Date: 05/27/2022

Re: **Soil Suitability for Foundation Installation**
Location: Lot 131 Quail Glen (164 Donatella Way Angier, NC)
JDS Project No.: RDU2205269
Date of Inspection: 5/26/2022
Foundation Type: Basement

FOUNDATION PLAN
SCALE: 1/4" = 1'-0"

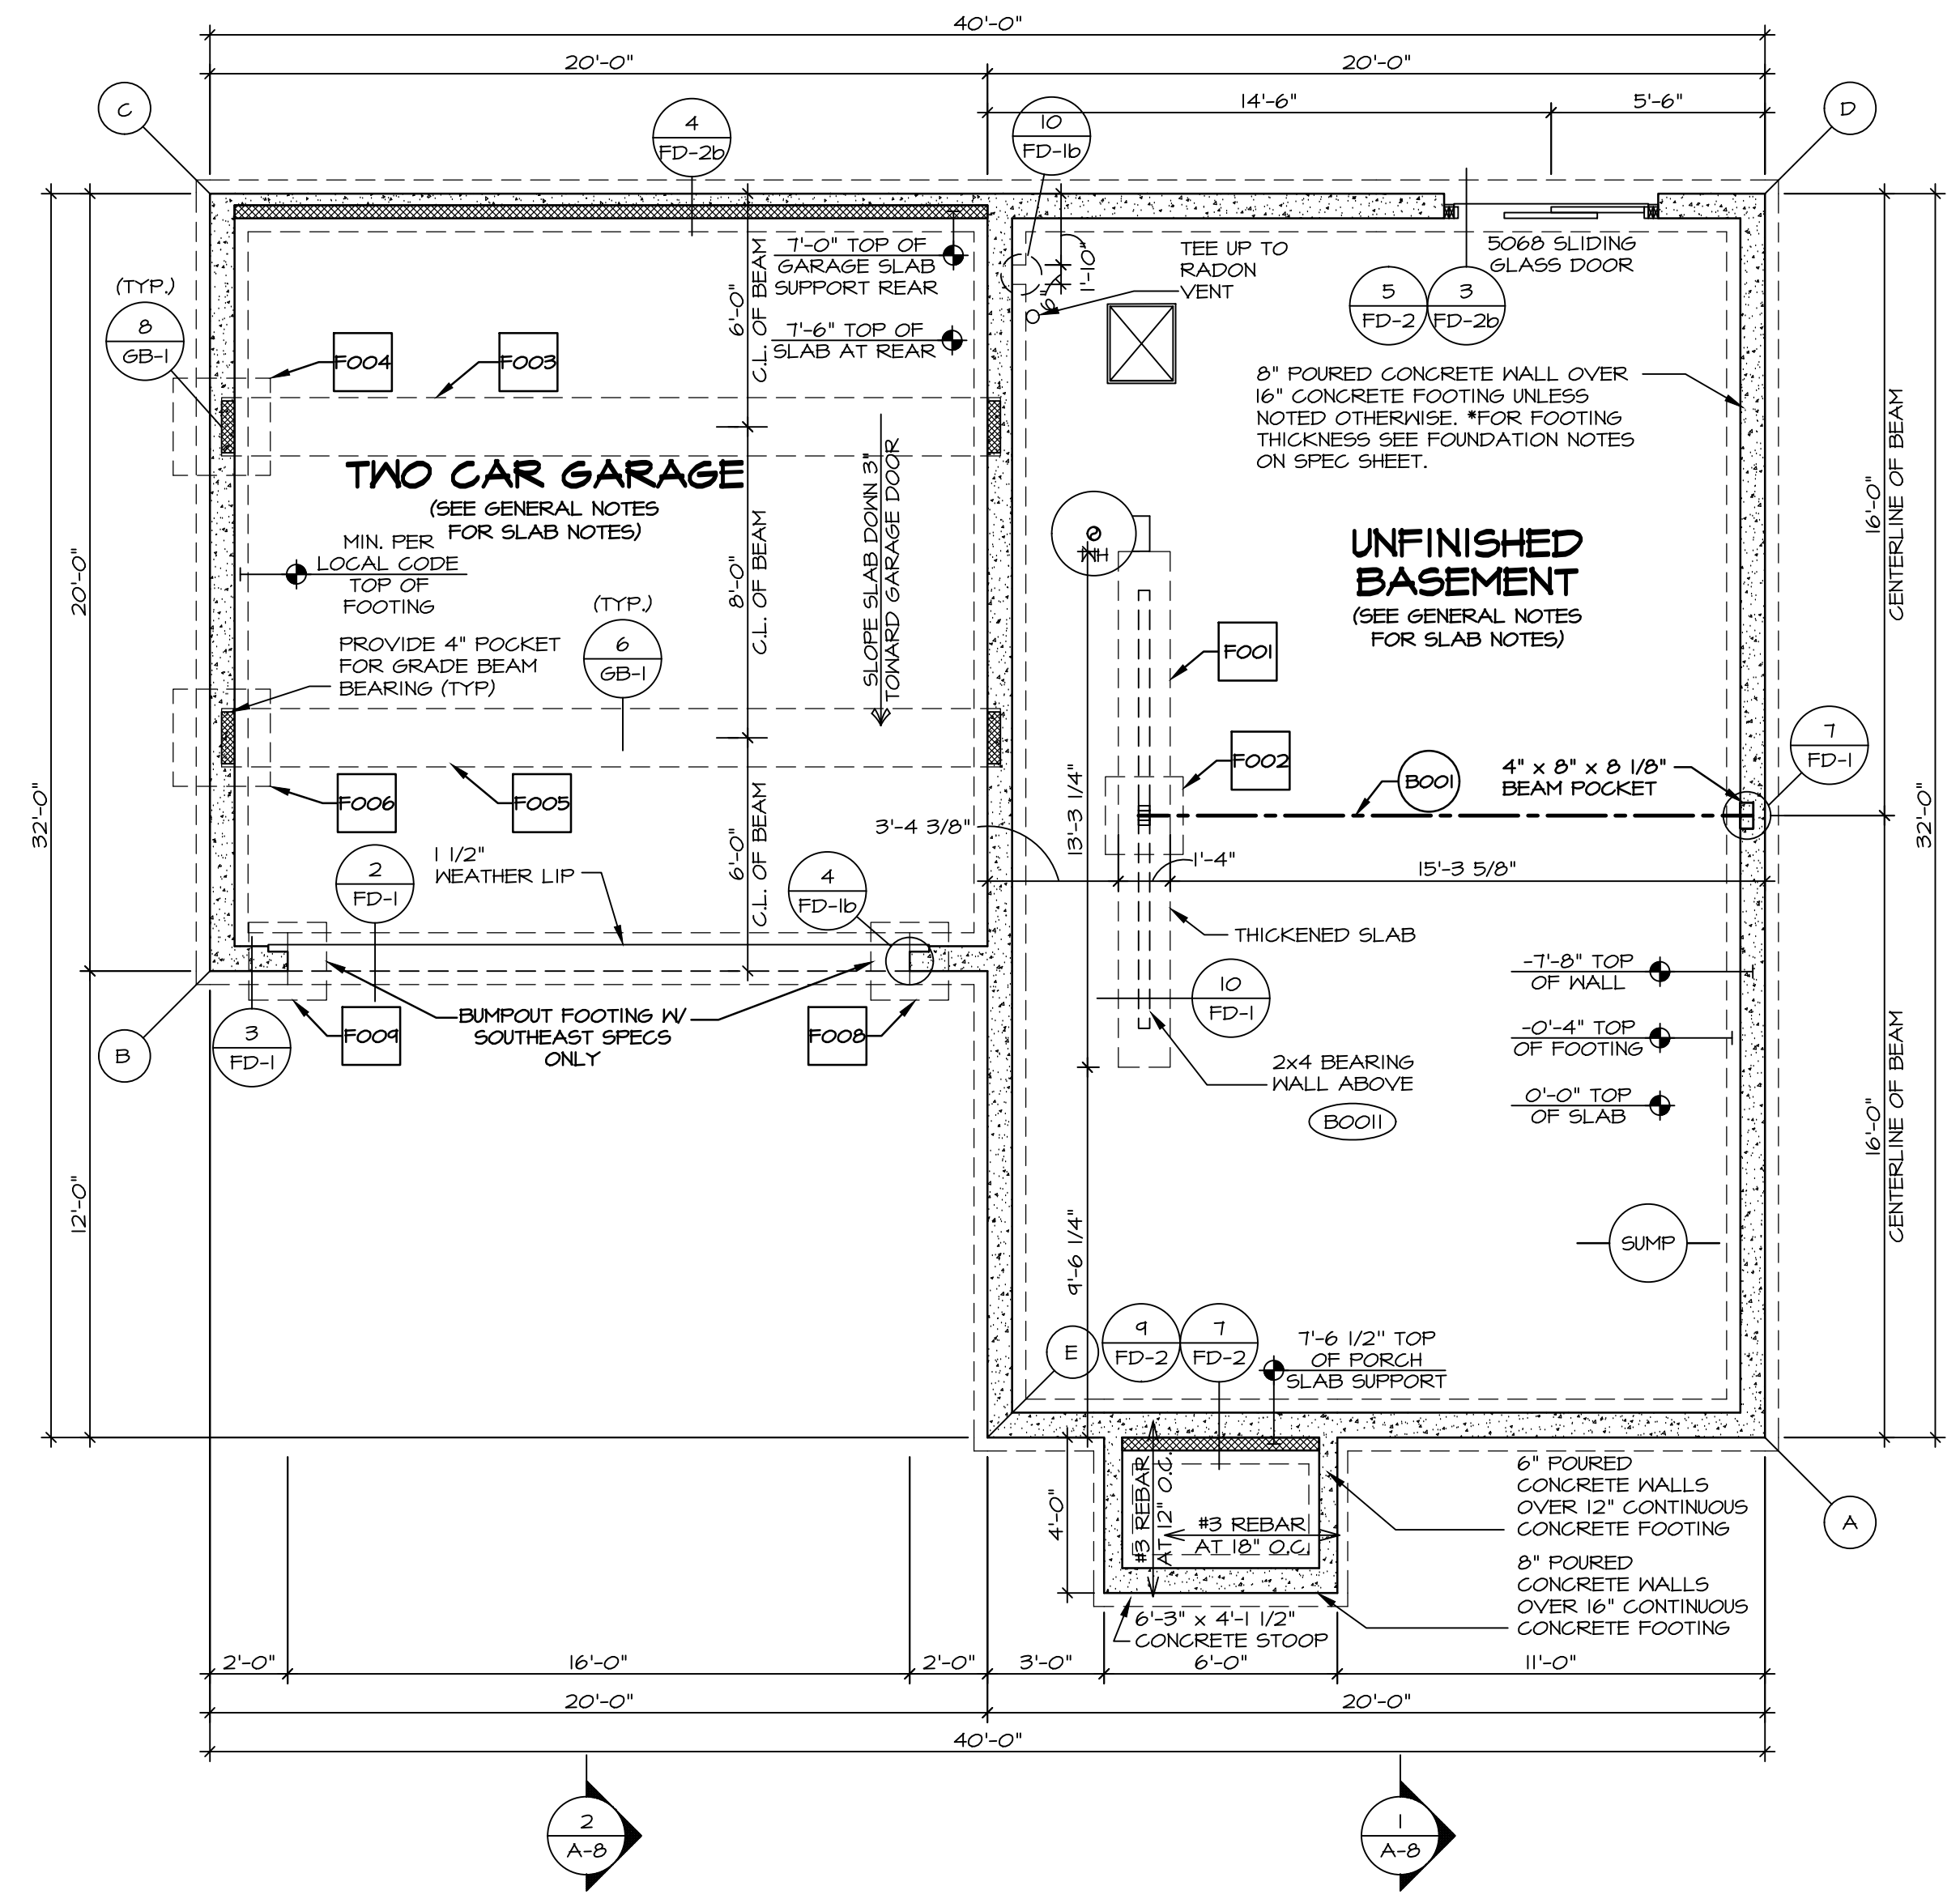
The exposed soils have been observed and tested for adequate bearing capacity (Probe and DCP). Based on our review and testing, the soil and conditions for the foundation are suitable for the minimum required bearing pressure of 2000 psf. Additionally, the over-excavated areas (multiple locations, 1 ft to 1.5 ft) shall be back-filled with full depth concrete.
